Submission ID: 34868

Jonathan Tennant on behalf of the Aldington and Mersham Support Group

ISH 3 on 25th February 2025 - PROW

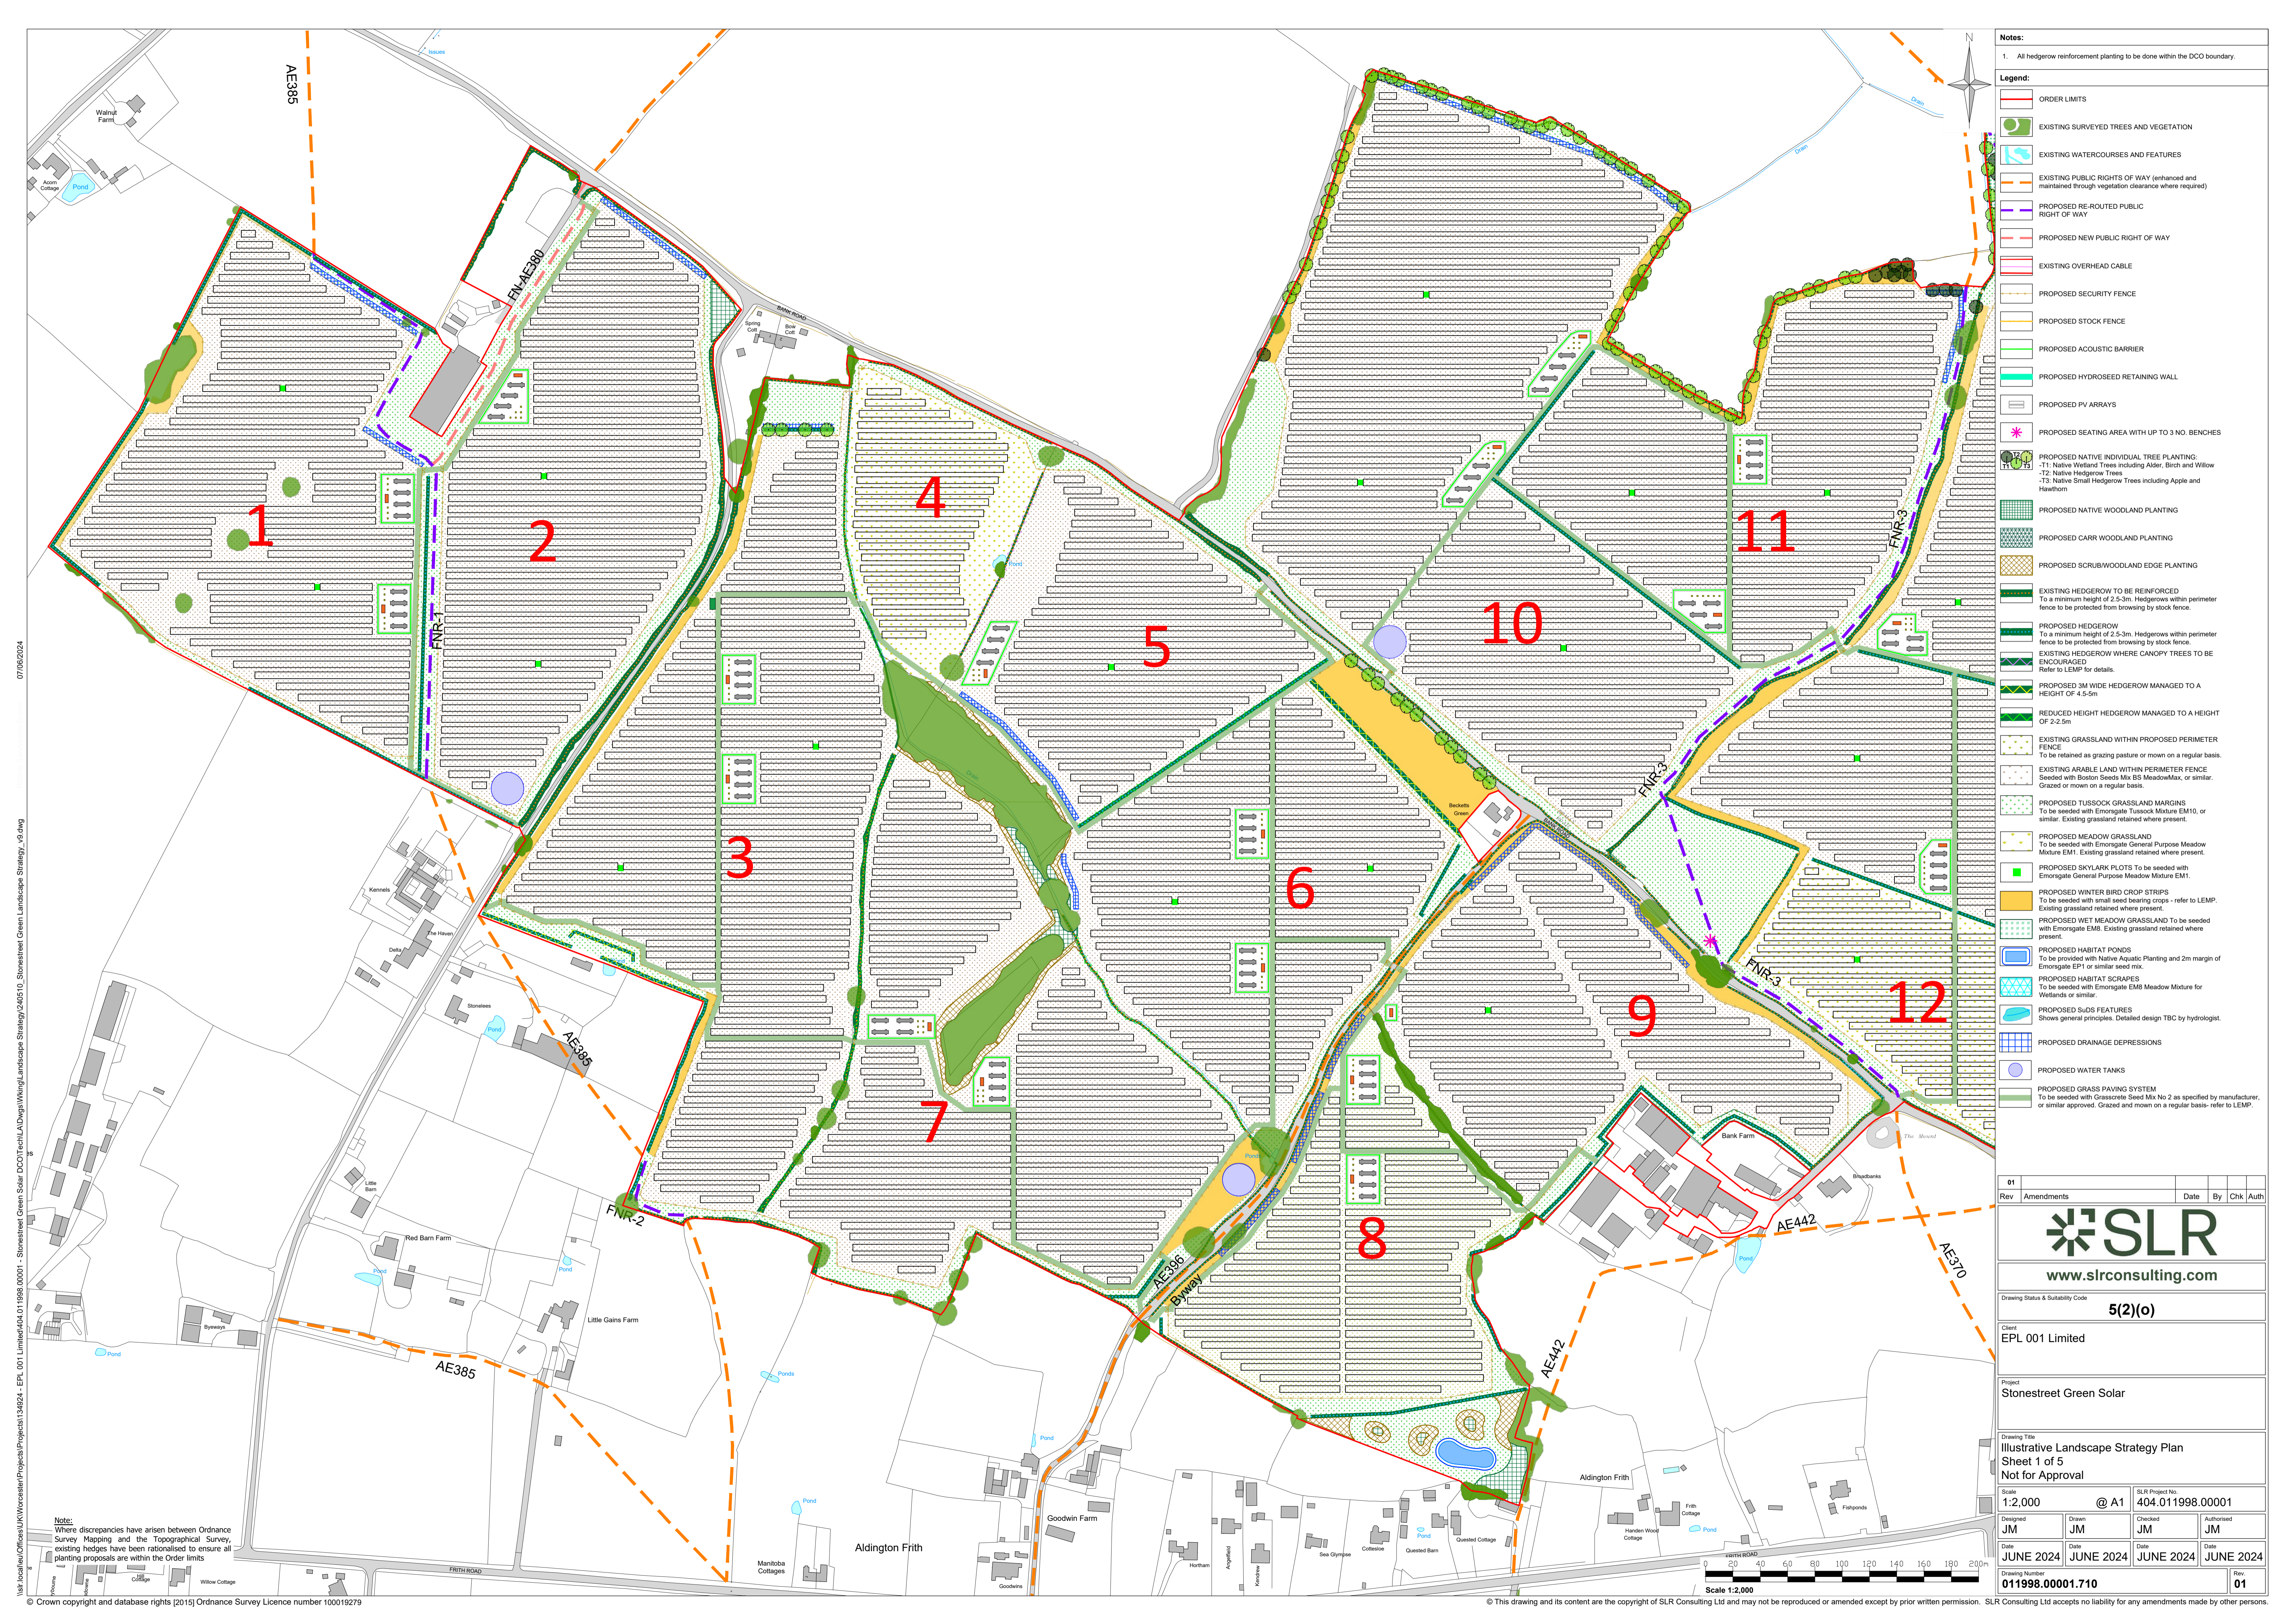
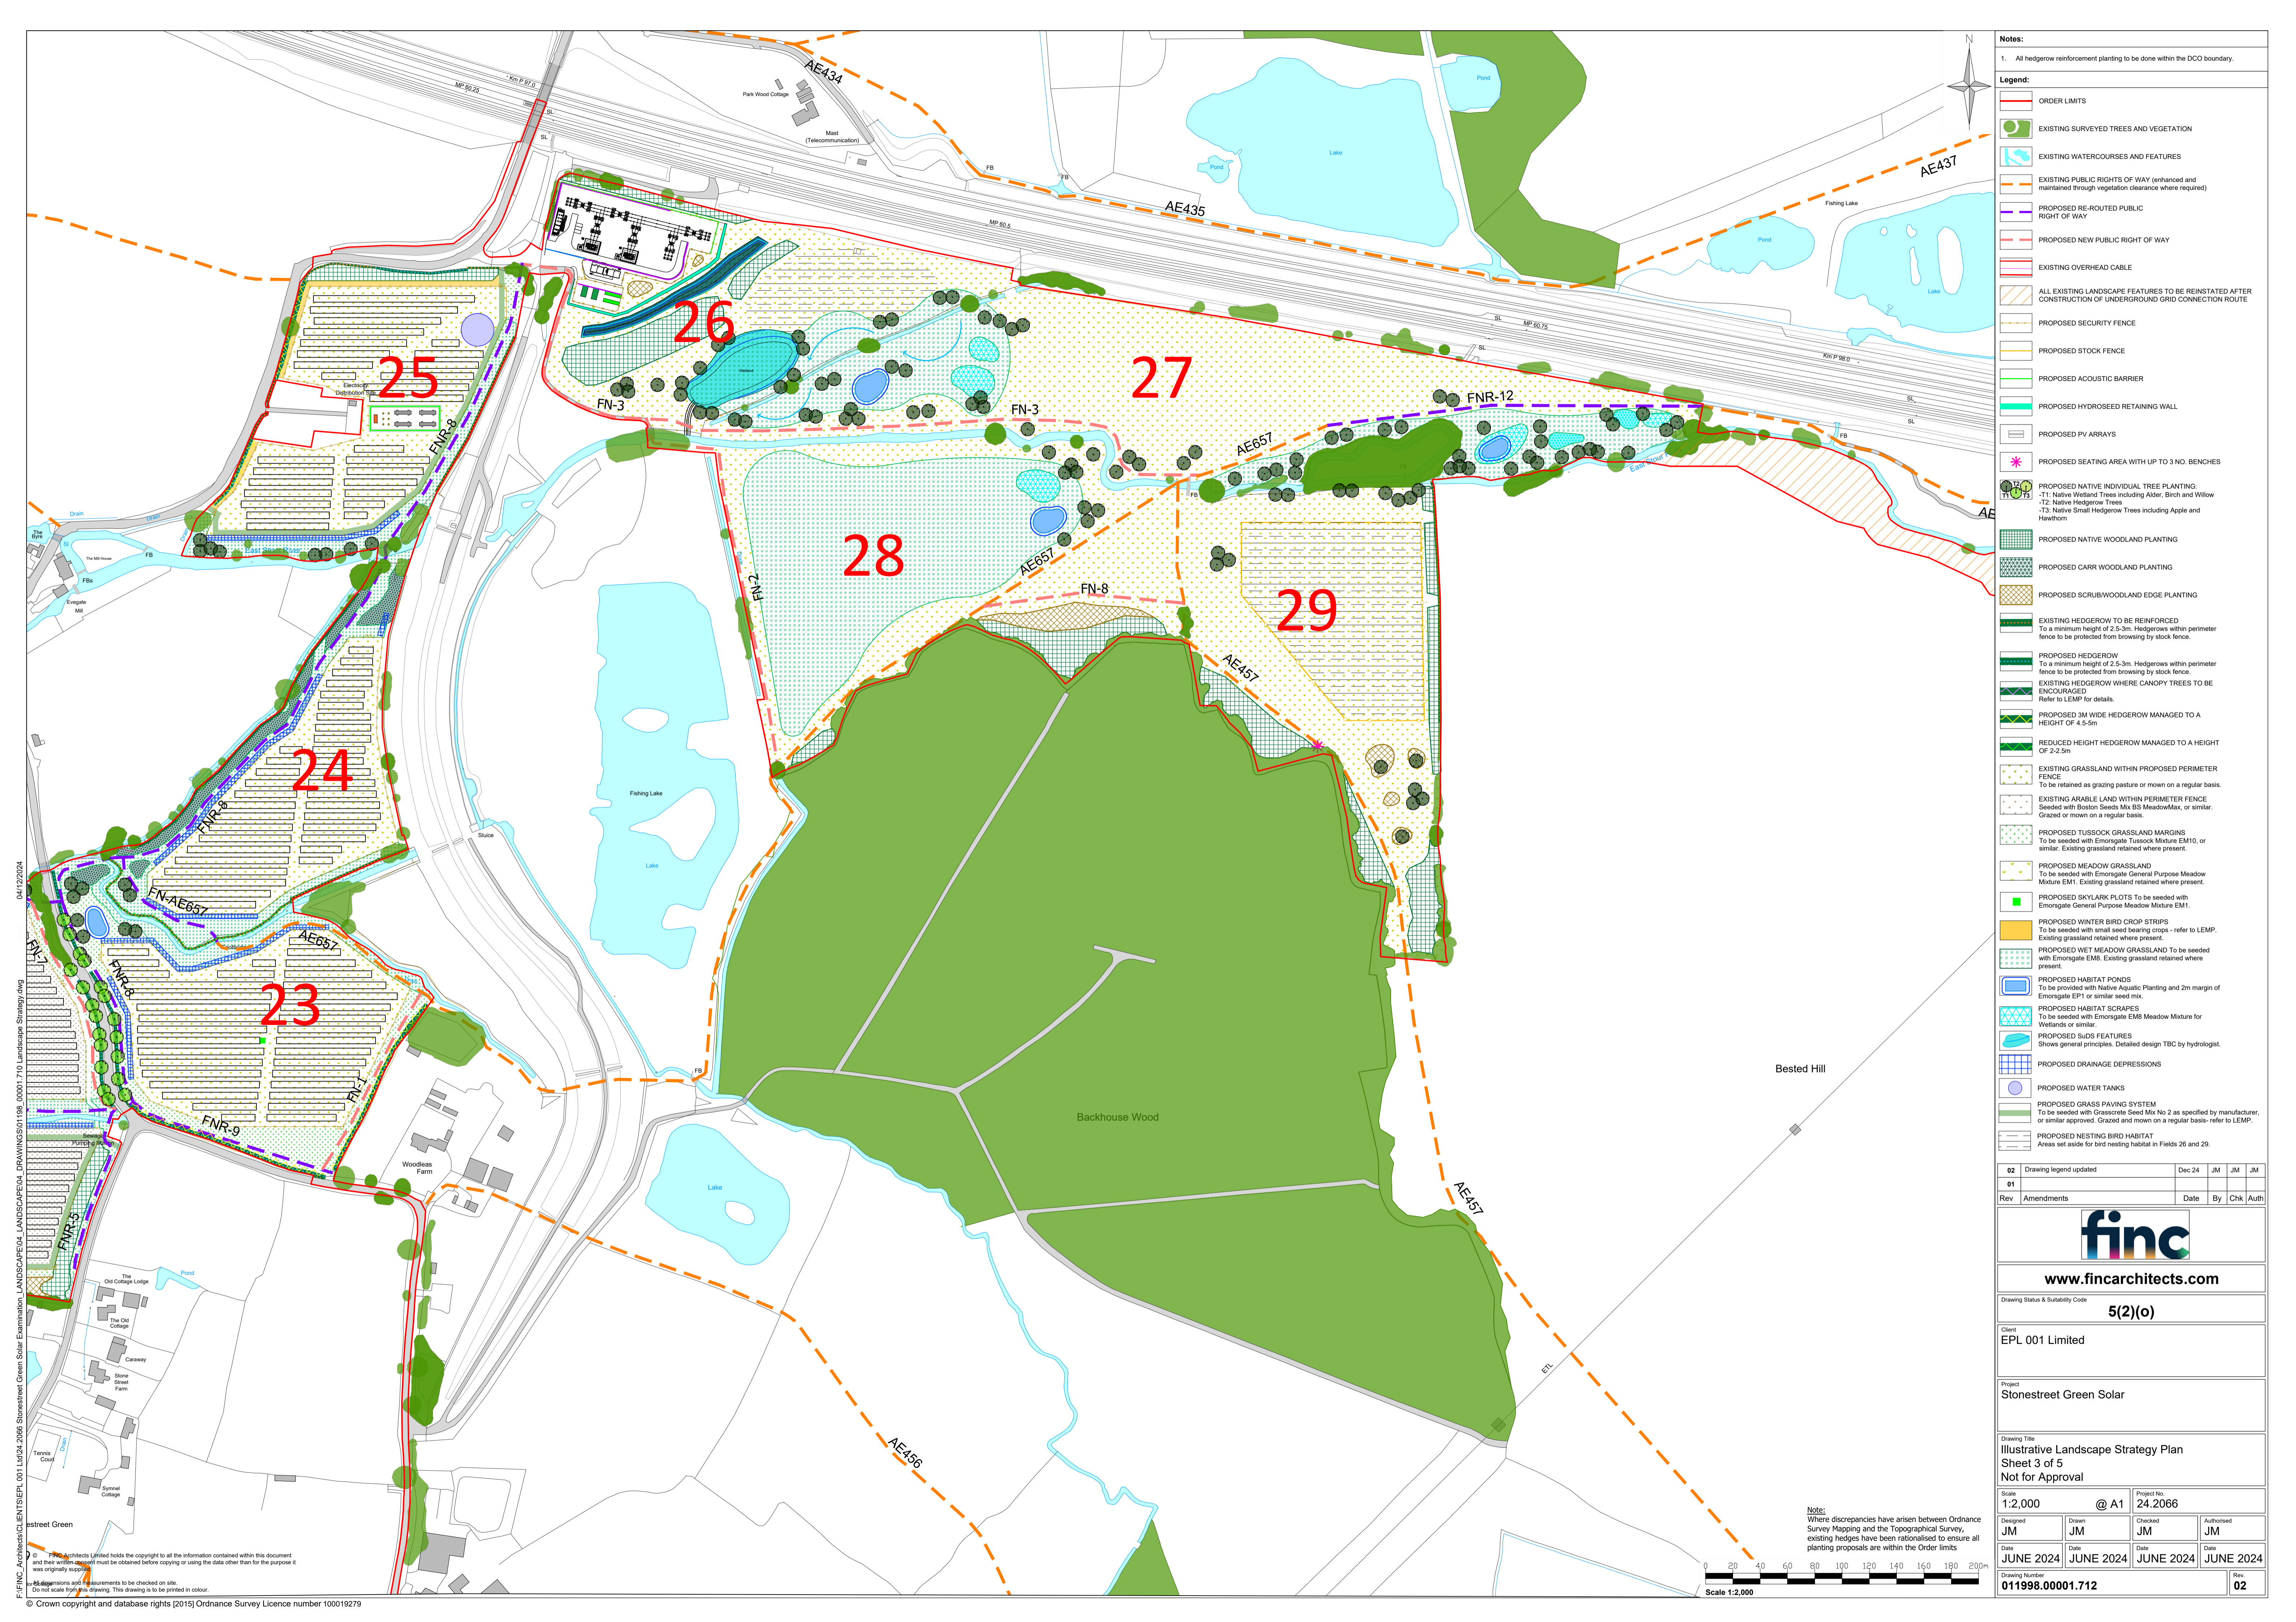
I would like to focus on just one aspect today. I have studied the illustrative plans submitted by the applicant reference **APP 013** and like others reviewed the numerous proposed diversions. Many of these changes are significant, circuitous and, in all cases will diminish enjoyment. Put bluntly, the new setting of nearly all of the paths within the red line boundary will be so bad that it is doubtful people will wish to walk any of them in the future.

What is so striking when looking at the illustrative plans is not only the angular and laborious diversion of many footpaths but the fact that the logical mitigation of planting hedges adjacent to the security fencing is almost non-existent. Across nearly 500 acres of development, I can only find evidence of this happening for short distances notably in fields 2, 18 and 21. Field 18 is adjacent to Calleywell Lane where there will be some native tree planting beside new footpath FNR 5 for about 150 metres heading out on what will be a new, longer and very circuitous route towards Mersham.
